Rezoning Transportation Analysis

Petition Number: 2020-070

General Location Identifier: Tax ID 06109202

Date	Description
05-19-20	First Review

SHEET NUMBER
RZ-1

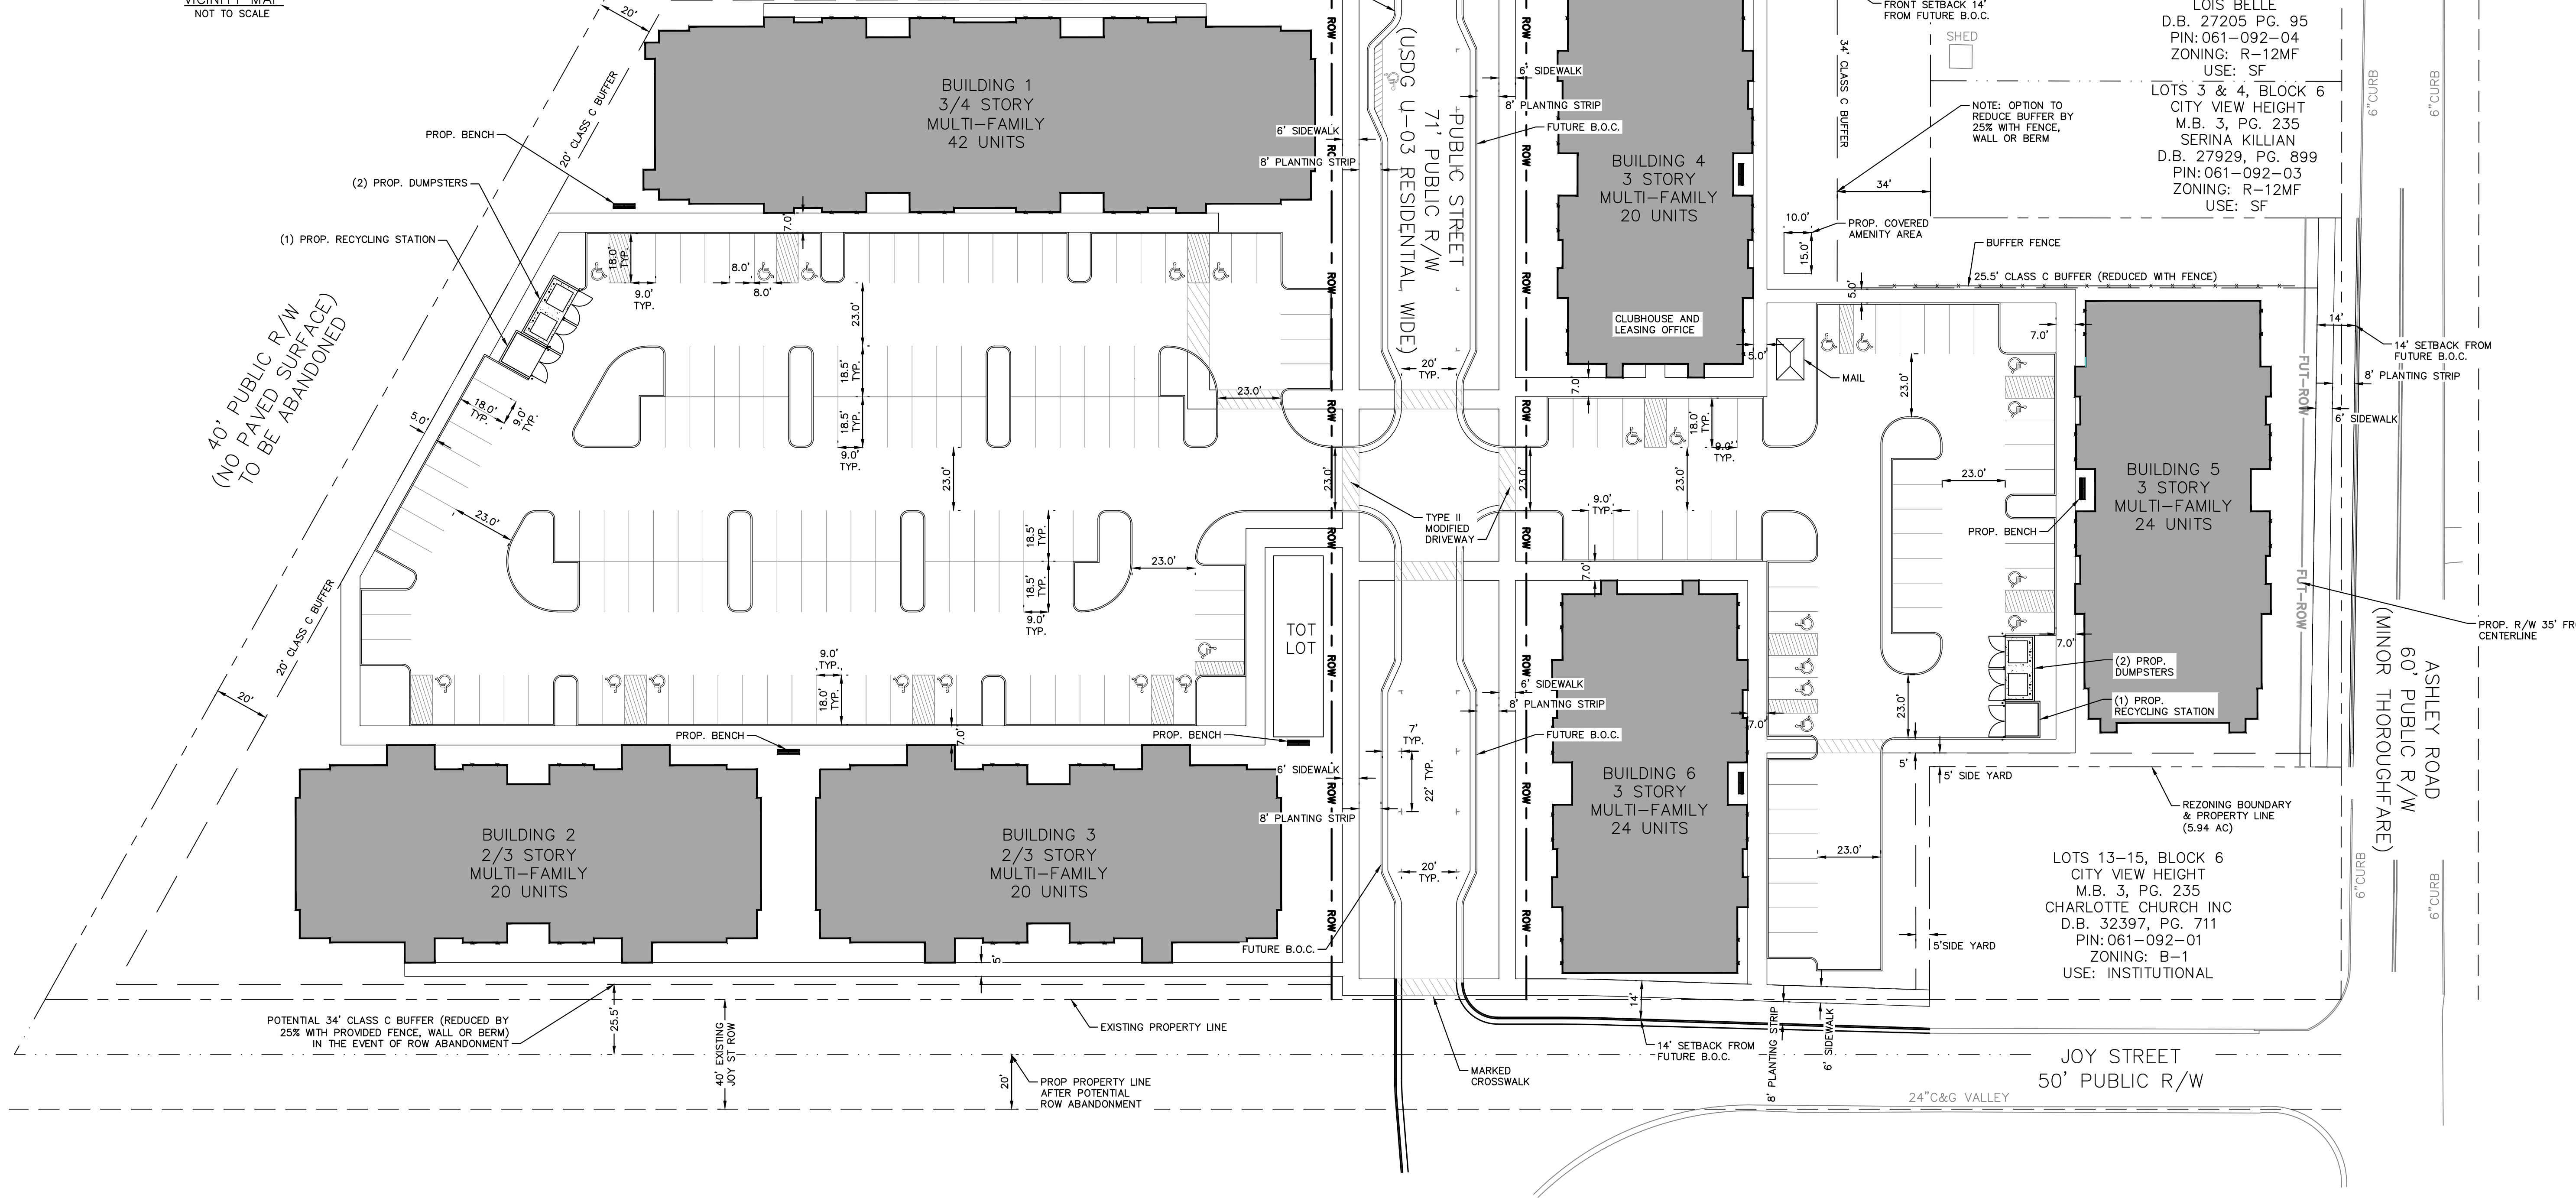
1. **Curblines** The proposed zoning district has a setback measured from back of the existing or proposed future curblines.
 - a. **Ashley Road:** The typical future location of curb and gutter is 21.5-feet from road center line to accommodate for one thru lane and a buffered bike lane, in accordance with the Charlotte BIKES council-adopted policy.

- b. **Bullard Street:** Location of curb and gutter should be moved to 17.5-feet from road centerline, per Charlotte Land Development Standards Manual (CLDSM) standard detail *USDG U-03A - Local Residential Wide Section*.

- c. **Joy Street:** Location of curb and gutter should be moved to 17.5-feet from road centerline, per Charlotte Land Development Standards Manual (CLDSM) standard detail *USDG U-03A - Local Residential Wide Section*. Please confirm that the proposed curb line transitions at a minimum of a 20:1 horizontal slope to tie back into the existing Joy Street curb line.

The site plan should show the curb and gutter labeled and dimensioned from the centerline for each road.

2. **Traffic Study** A Traffic Impact Study is not necessary for the complete review of this petition.
3. The petitioner should revise the site plan and conditional note(s) to commit to construct an 8-foot minimum planting strip and 6-foot minimum sidewalk along Ashley Road per Chapter 19 of the City Code and Chapter 20 of the Subdivision Ordinance. If the proposed density exceeds 12 dwellings per acre, all proposed sidewalks should be 8-foot minimum.

4. The petitioner should revise the site plan and conditional note(s) to provide MUTCD stop signs at all public street intersections.
5. The petitioner should revise the site plan and conditional note(s) to provide MUTCD 25 mph speed limit signs on the new proposed public street.

6. The petitioner should revise the site plan and conditional note(s) to provide a northbound left-turn lane at either the intersection of Ashley Road & Joy Street or Bullard Street & Joy Street.

7. The petitioner should revise the site plan and conditional note(s) to remove the proposed marked cross walks at the proposed public street intersections. Marked crosswalks are incorporated at signalized intersections or at appropriate midblock pedestrian crossing facilities, in reference to the council-adopted Charlotte Walks Plan.
